Rezoning Transportation Analysis

Petition Number: 2022-210

Revision Log:

Date	Description
05-24-2023	First Review (PDM)
06-21-2023	Second Review (DR)
08-23-2023	Third Review (PDM)
09-20-2023	Fourth Review (JP)
10-26-2023	Fifth Review (JP)
11-27-2023	Sixth Review (DR)

RZ-03

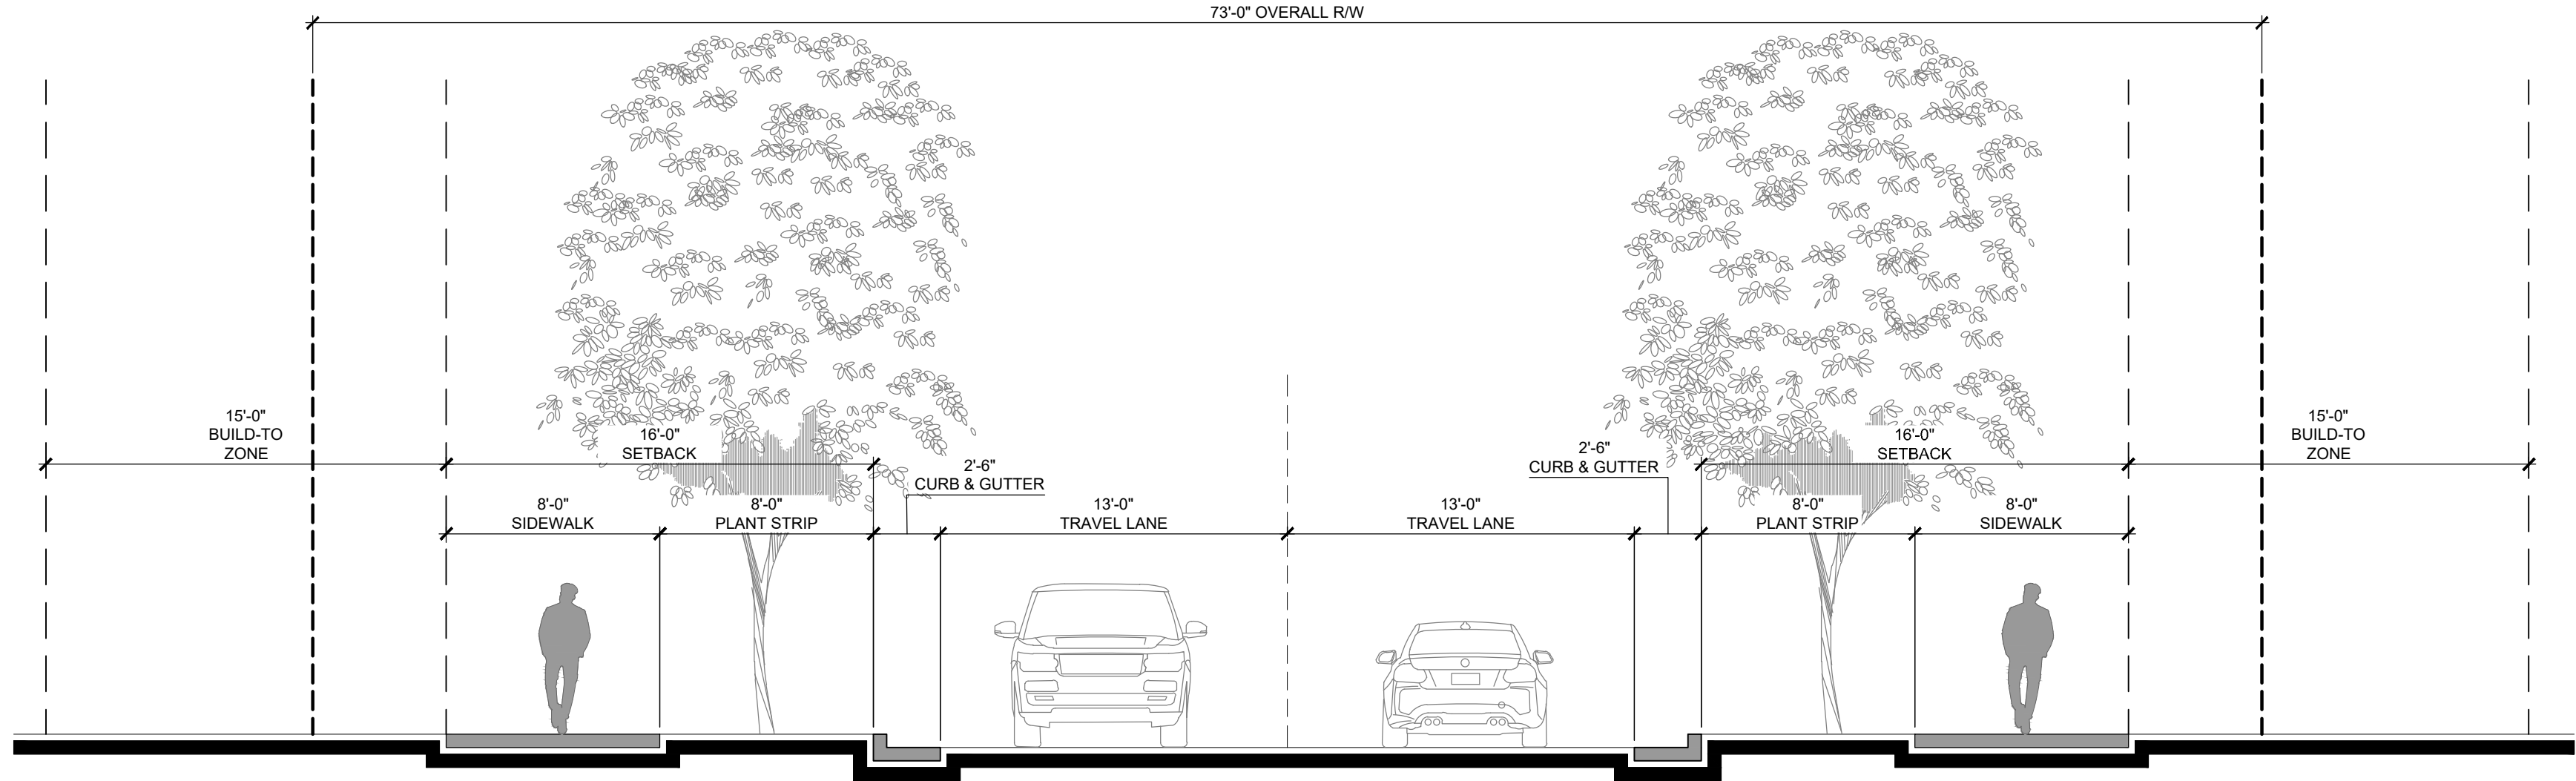
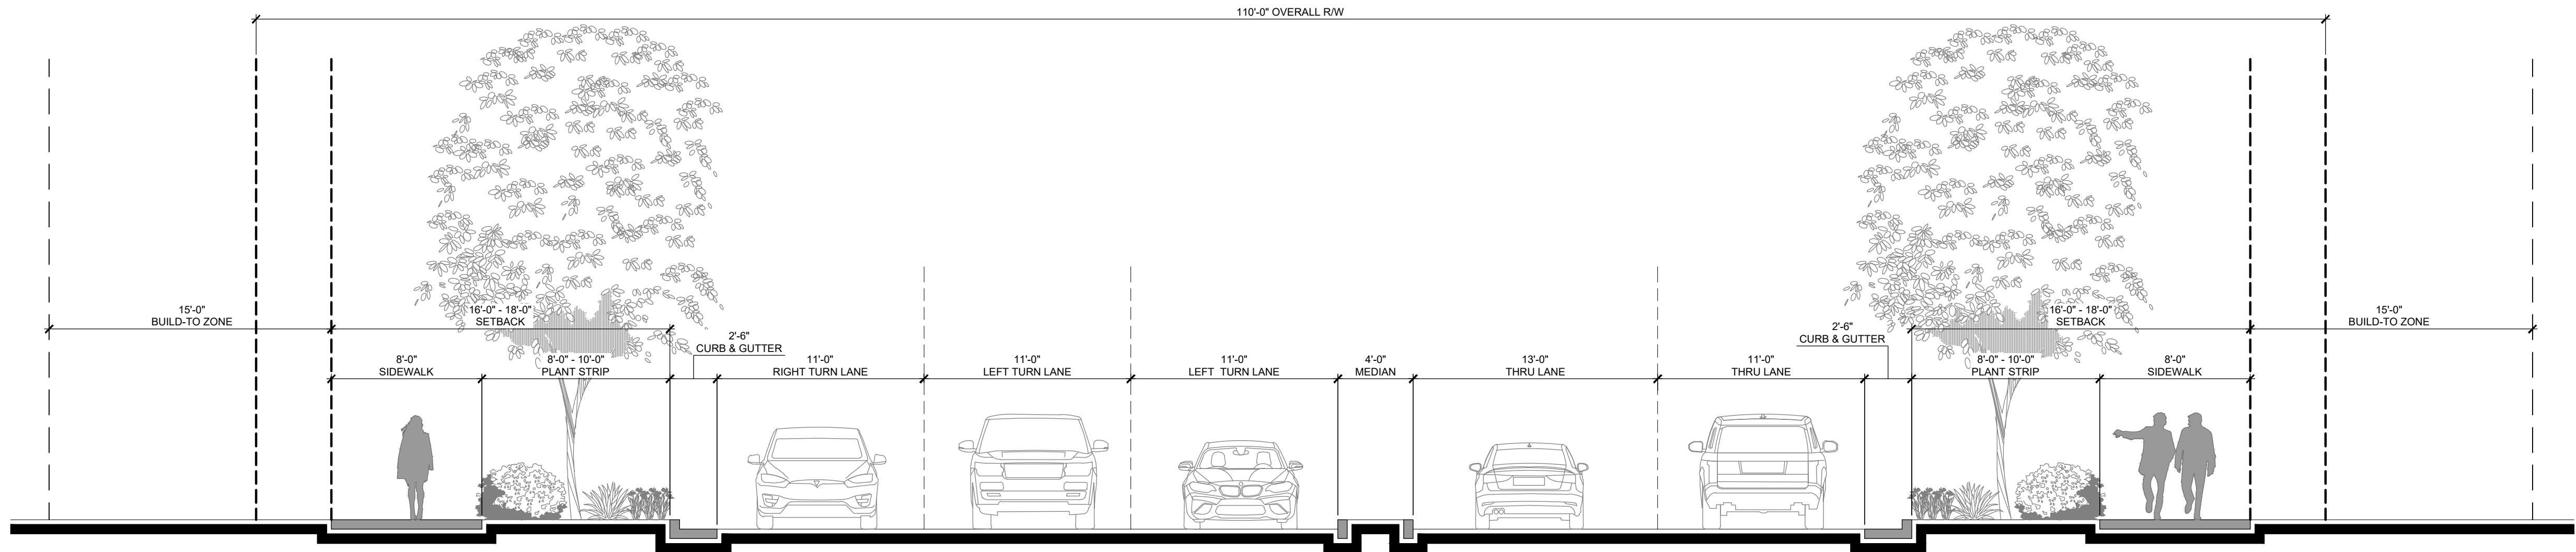
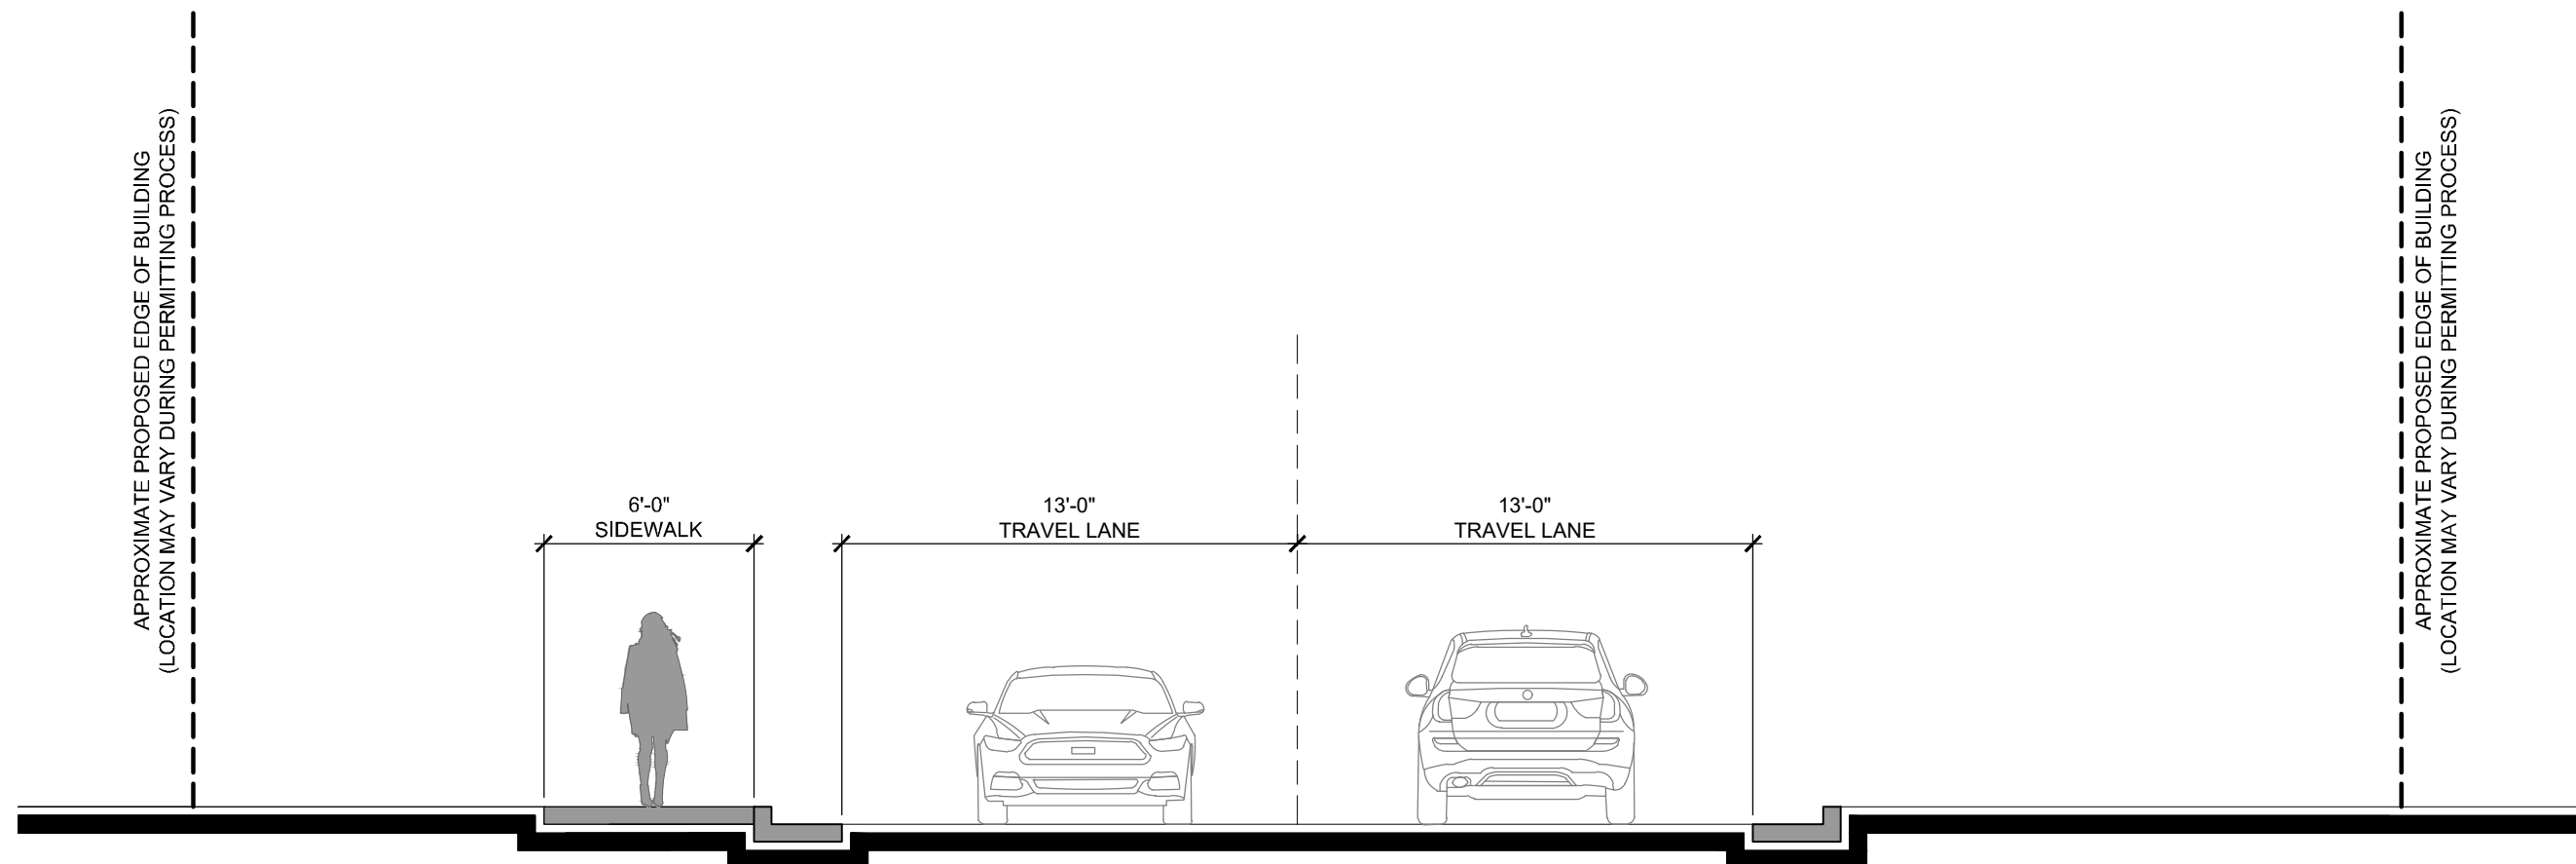
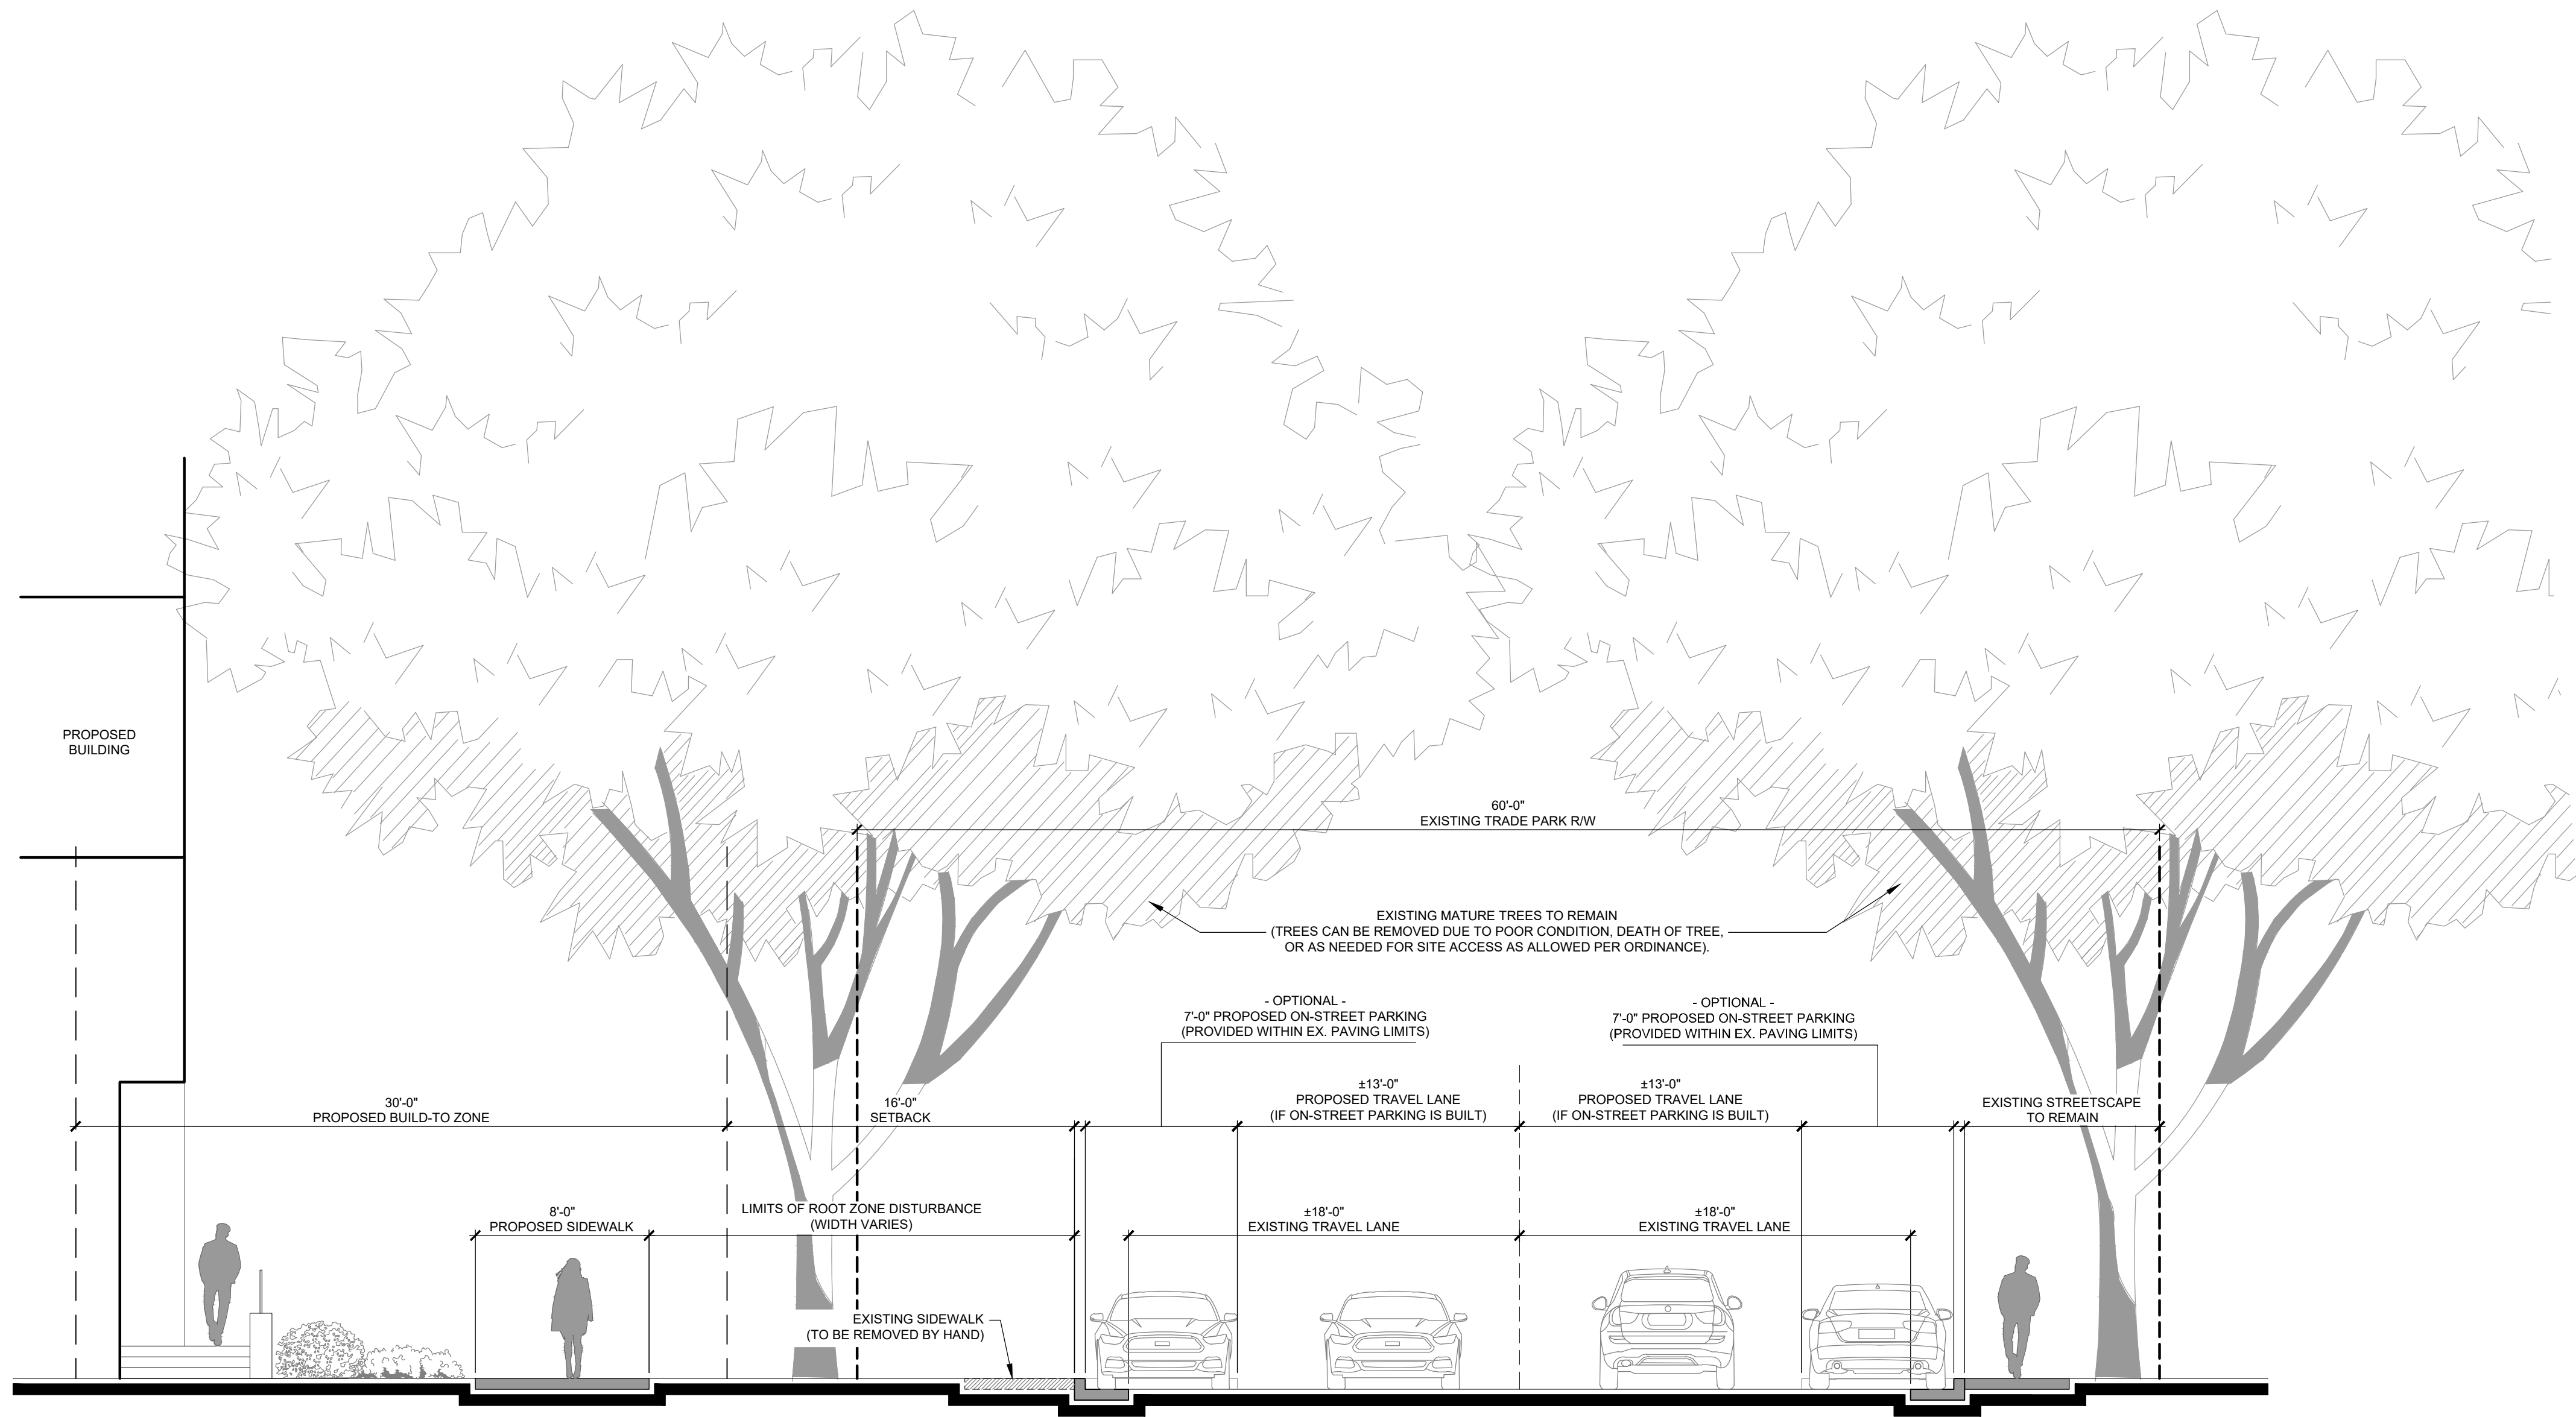
Outstanding Comment 9.20.23: Revise internal street network to standard public street typical sections per the CLDSM or provide additional information on existing constraints for review and approval of nonstandard typical sections.
